**Consultation Response from KC,  
Ecology Unit****2021/94280 land at, Lady Ann Road, Soothill, Batley, WF17 0PY****Erection of 65 dwellings with associated works****Date Responded: 02/11/2023****Responding Officer: Gareth Hey****Responding Ref:**

**Figure 3.2** Trees with BRS. Moderate suitability = red circle. Low = green circle.

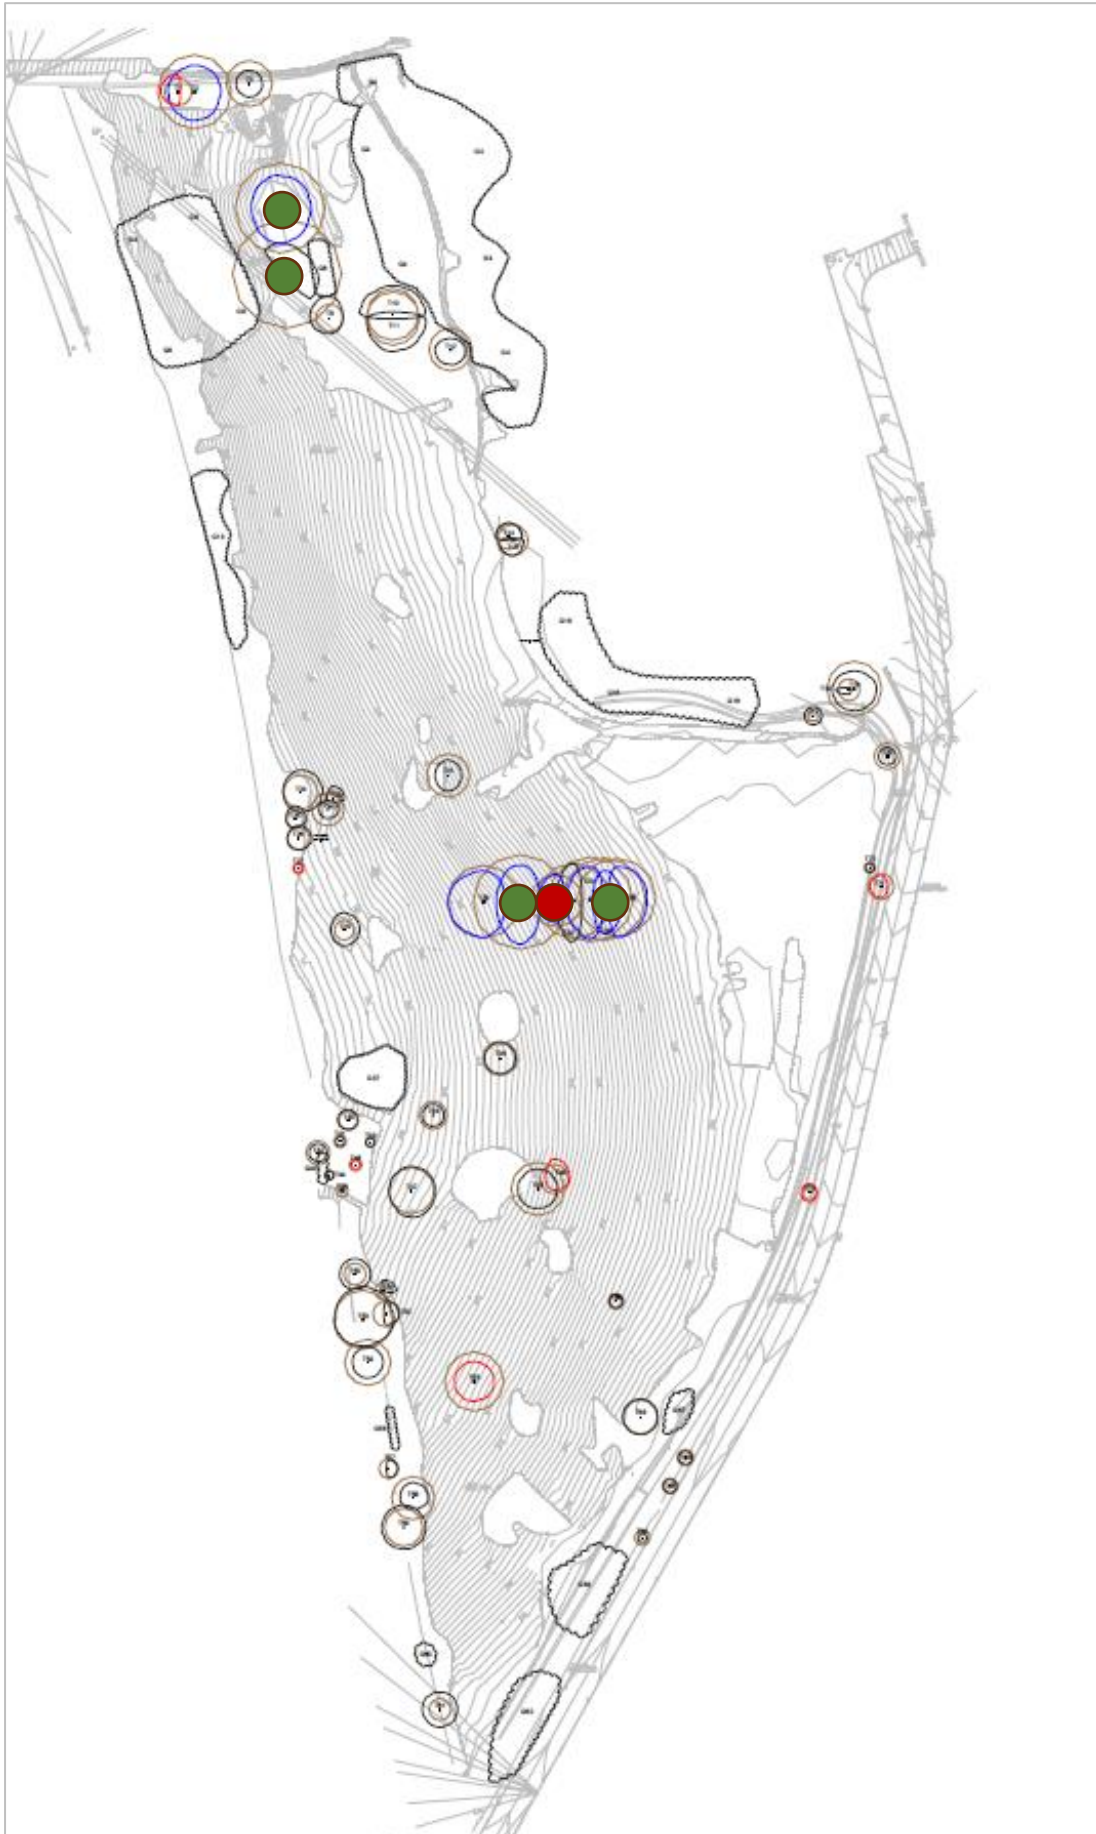
The EclA details that the proposed development will result in the loss of a significant area of low value habitat, this is generally accepted as the main habitat that is to be lost to facilitate the proposed development is species poor grassland. However, the submitted EclA details that five trees were identified as having bat roost suitability. The submitted EclA does not provide a plan showing the exact locations of the above-mentioned trees and therefore, at this stage, it is unclear if the removal of the trees throughout the site as detailed in the submitted tree report will result in the loss of potential bat roosts. In order to determine if there will be no impacts on roosting bats, a plan should be provided within the EclA (or target notes provided on original plan) detailing the locations of the trees with potential roosting features. In any case, the EclA should fully address the impacts on the loss of the trees at the site. This information should be provided prior to determination. Aside from the above, I accept the conclusions of other receptors detailed within the EclA and standard conditions with regards to CEMP: Biodiversity and an invasive species management plan should be placed on any forthcoming consent to secure the recommendations outlined in the EclA.

- Prior to determination, the EclA should be updated to provide location of trees that contain suitable bat roosting features and if these trees are to be lost to facilitate the proposed development. If the trees are to be removed, it is recommended that additional survey effort in the form of aerial inspections are undertaken to determine if there are roosting bats present within these trees.
